**Consultation Response from KC,  
Highways Development Management****2024/91884 100, Penistone Road, Waterloo, Huddersfield, HD5 8QX****Formation of new dropped kerb / driveway alterations****Date Responded: 07/08/2024.****Responding Officer: D. Stainsby****Responding Ref: K11-7SE/4**

This application is for the formation of new dropped kerb / driveway alterations at 100, Penistone Road, Waterloo, Huddersfield, HD5 8QX

LAYOUT PLAN AS PROPOSED.

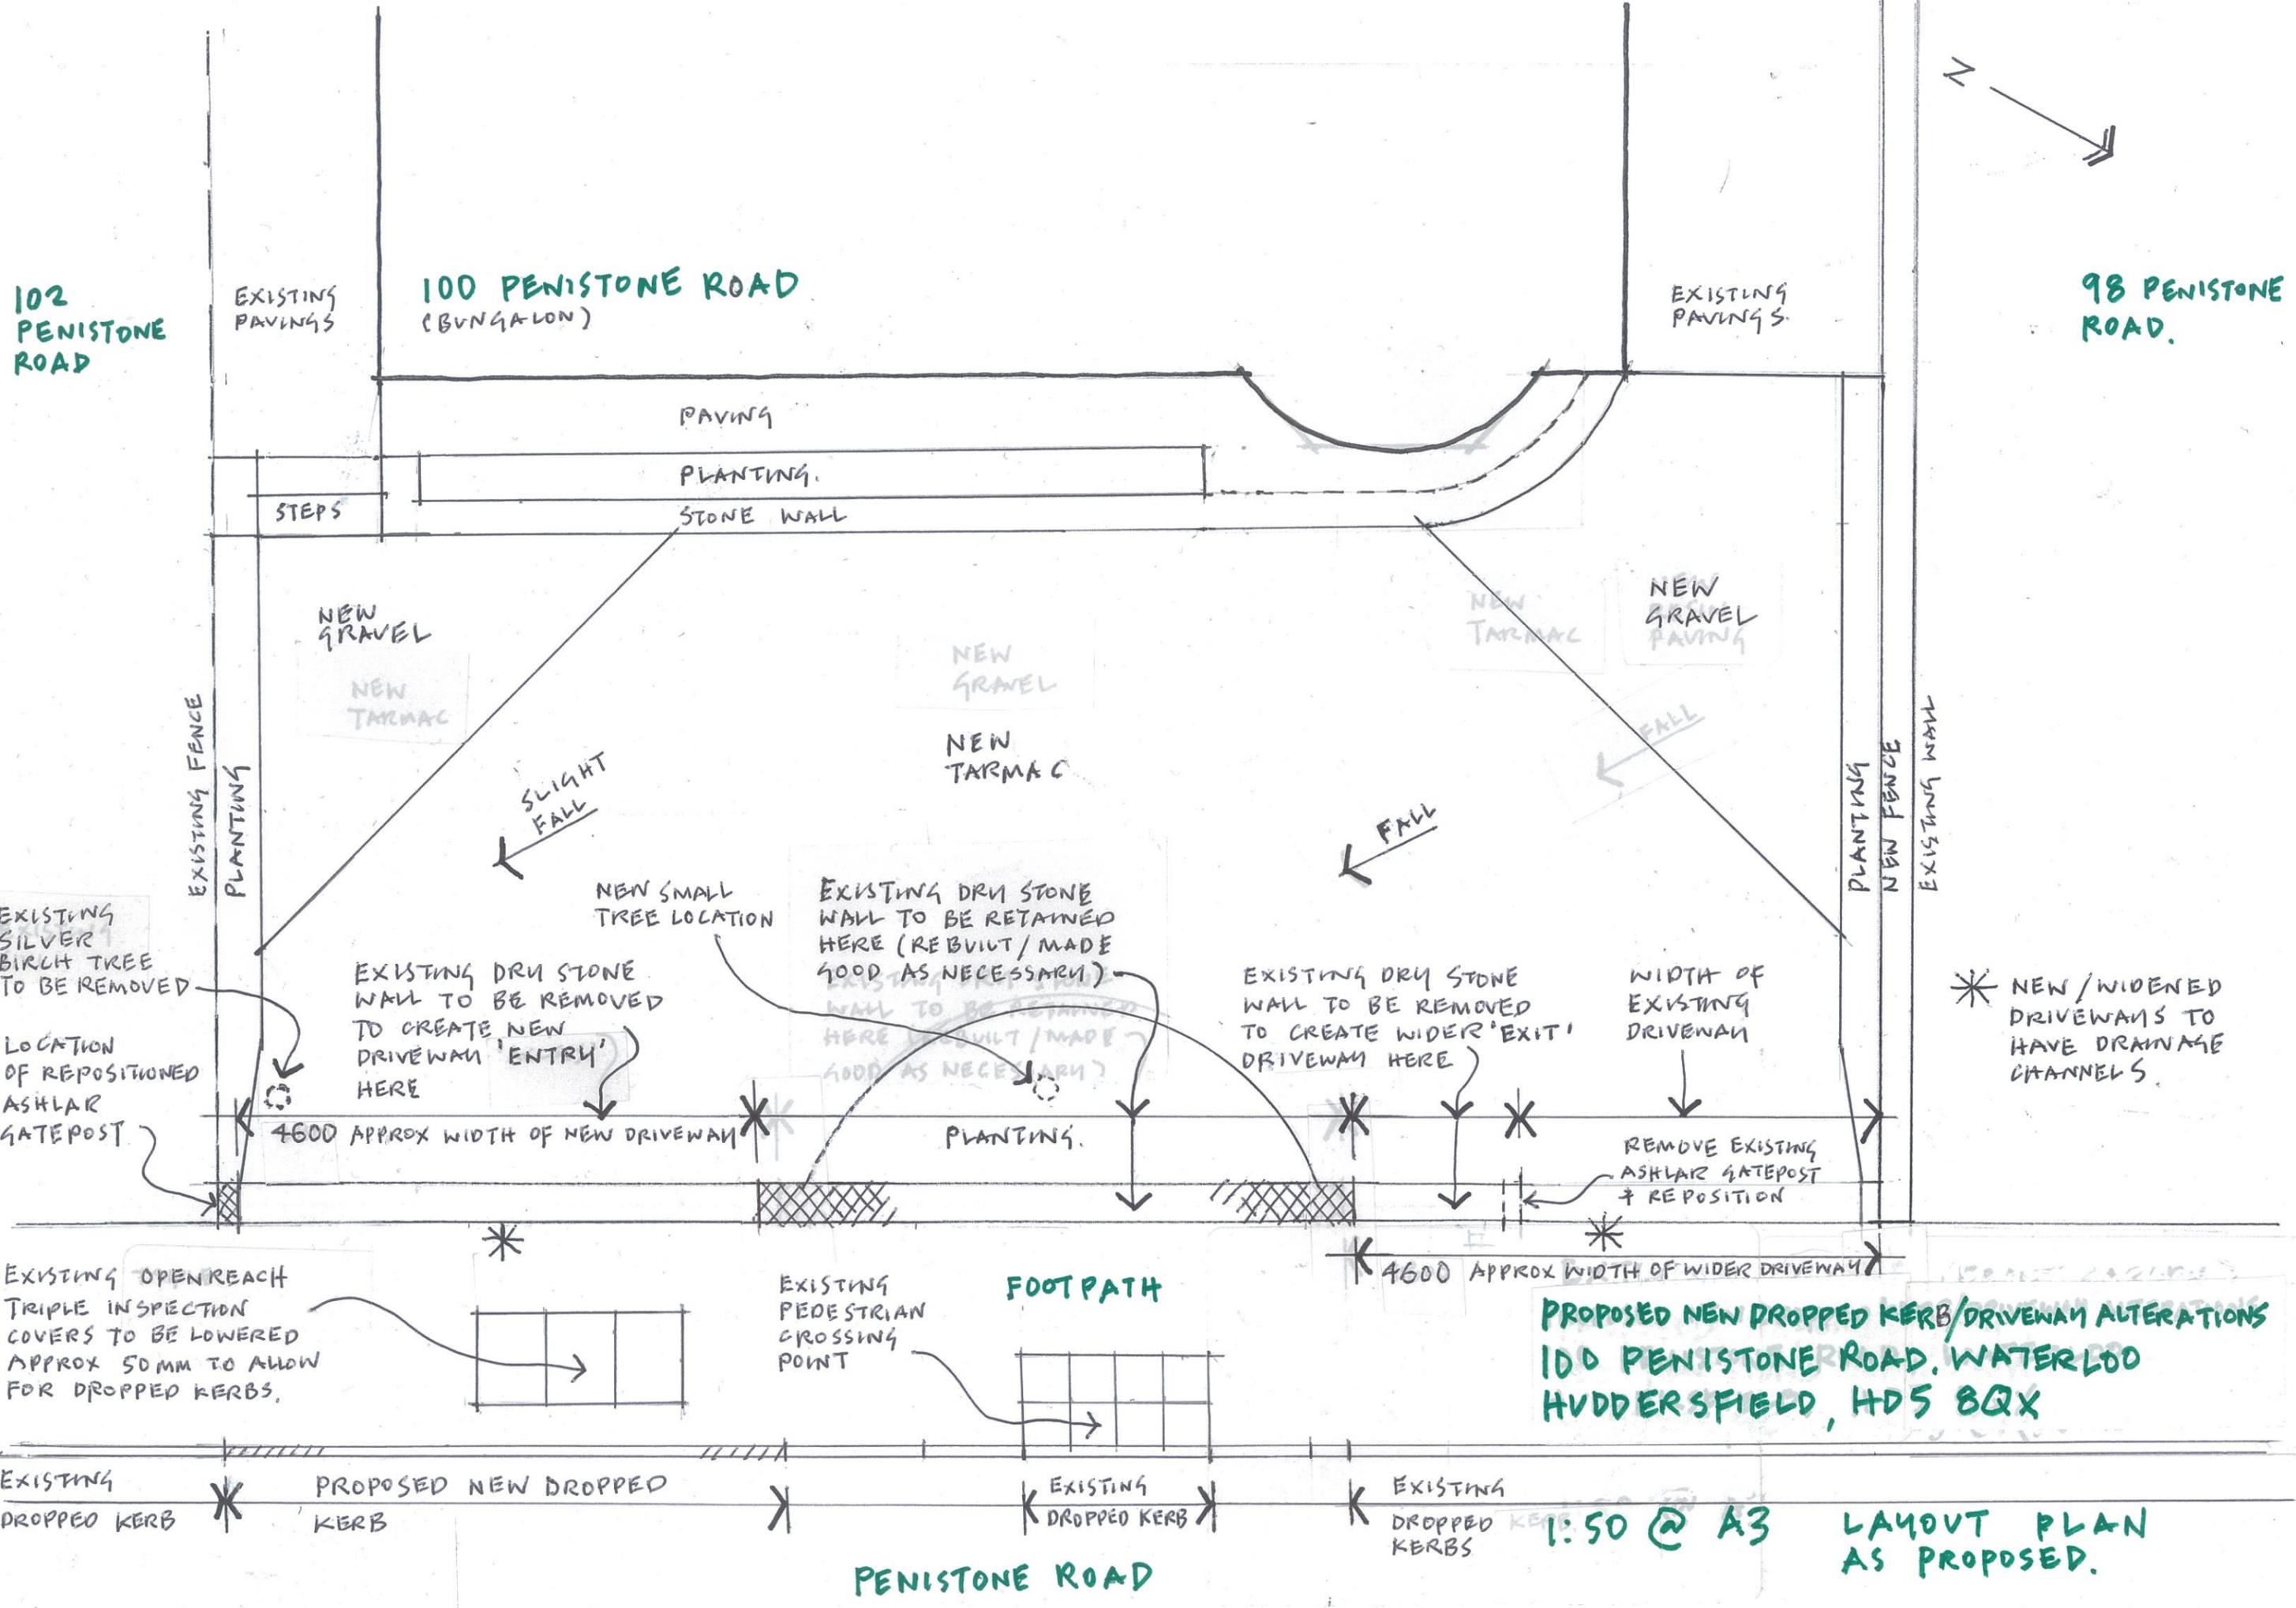
The property has an existing vehicle access which is narrow and is difficult to either reverse into or out of the property from the busy A629 Penistone Road.

The proposal to provide a new vehicle access and widen the existing access will improve the situation by enabling vehicles to enter and leave the site in forward gear, thereby negating the necessity to reverse either onto or from the A629 Penistone Road.

As a result, Highways DM would not wish to object to this application.

The changes to the access within the adopted highway fronting the property, to provide a dropped kerb, will need to be constructed under a section 184 agreement of the 1980 Highways Act (vehicle crossings over footways and verges). You are required to consult the Design Engineer (Kirklees Street Scene: 01484 221000) with regard to obtaining this permission and approval of the construction specification. Interference with the highway without such permission is an offence which could lead to prosecution.
